Subject: Land adj 1 Holkham Cottage, Burndell Road, Yapton

I write to you regarding Land adjacent to 1 Holkham Cottage, Burndell Road, Yapton – reference Y/5/19/DOC.

Proposed Elevation

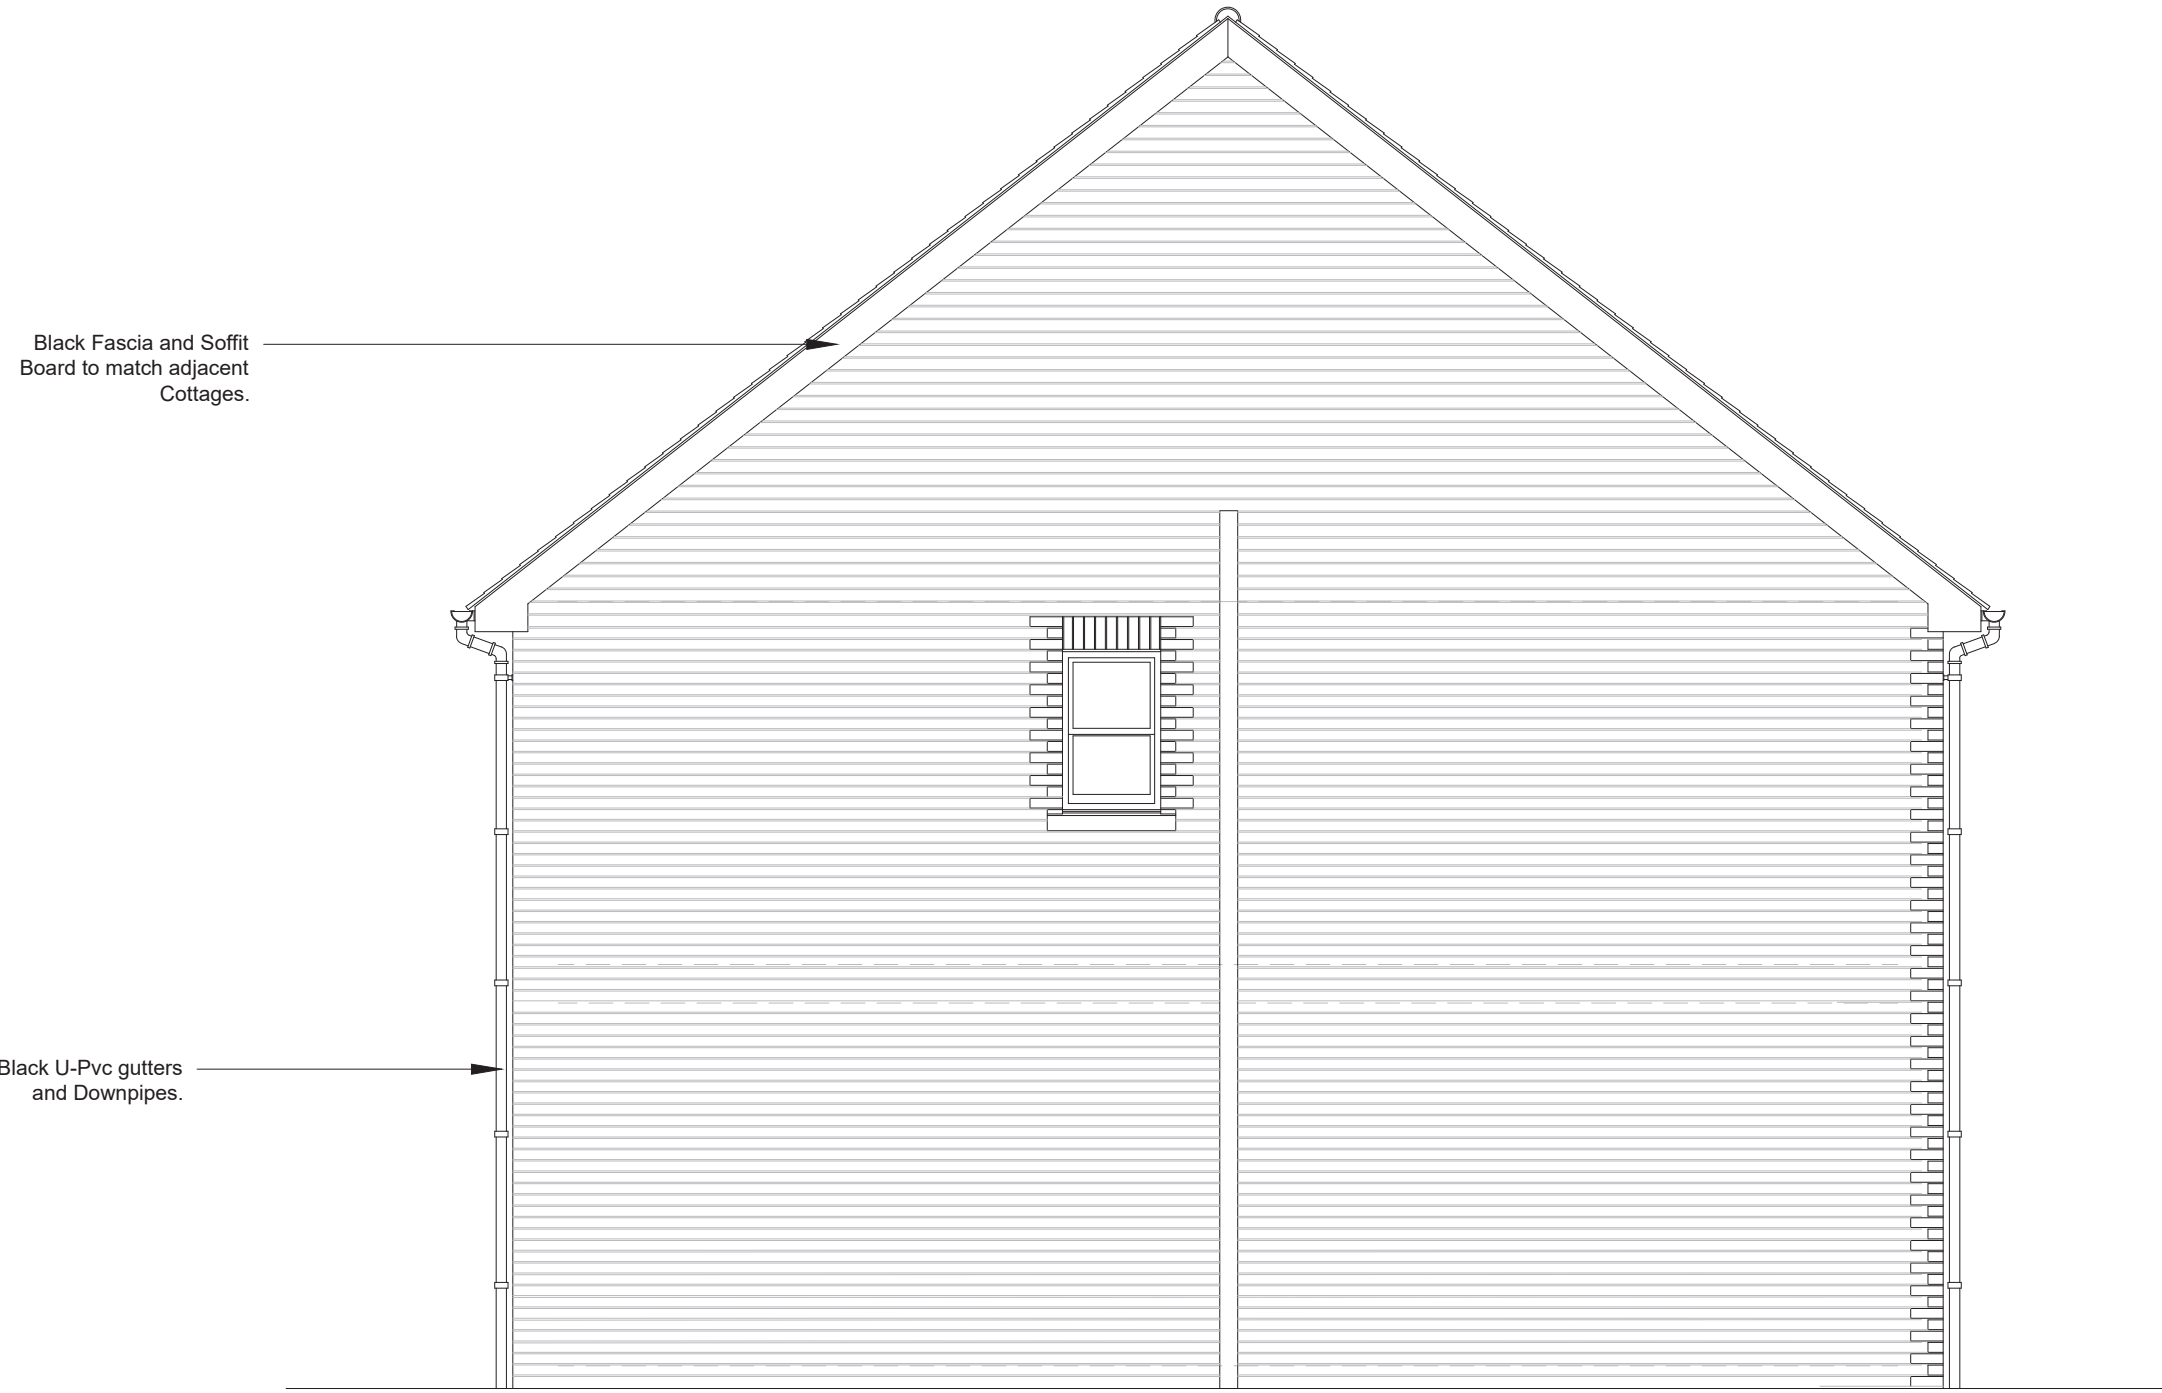
You should have received confirmation of the agreement to discharge condition 3 of planning application Y/47/18/PL, whilst looking at the drawings we have noticed there appears to be a slight difference to the approved plans of Y/47/18/PL and the Proposed elevations included within the DOC application. These appear to be the detailing around the windows and 'edges' of the dwellings, Y47/18/PL elevations indicate arches over the window however the revised drawing show a flat border almost.

We would advise that these can be dealt with through a Non material amendment.
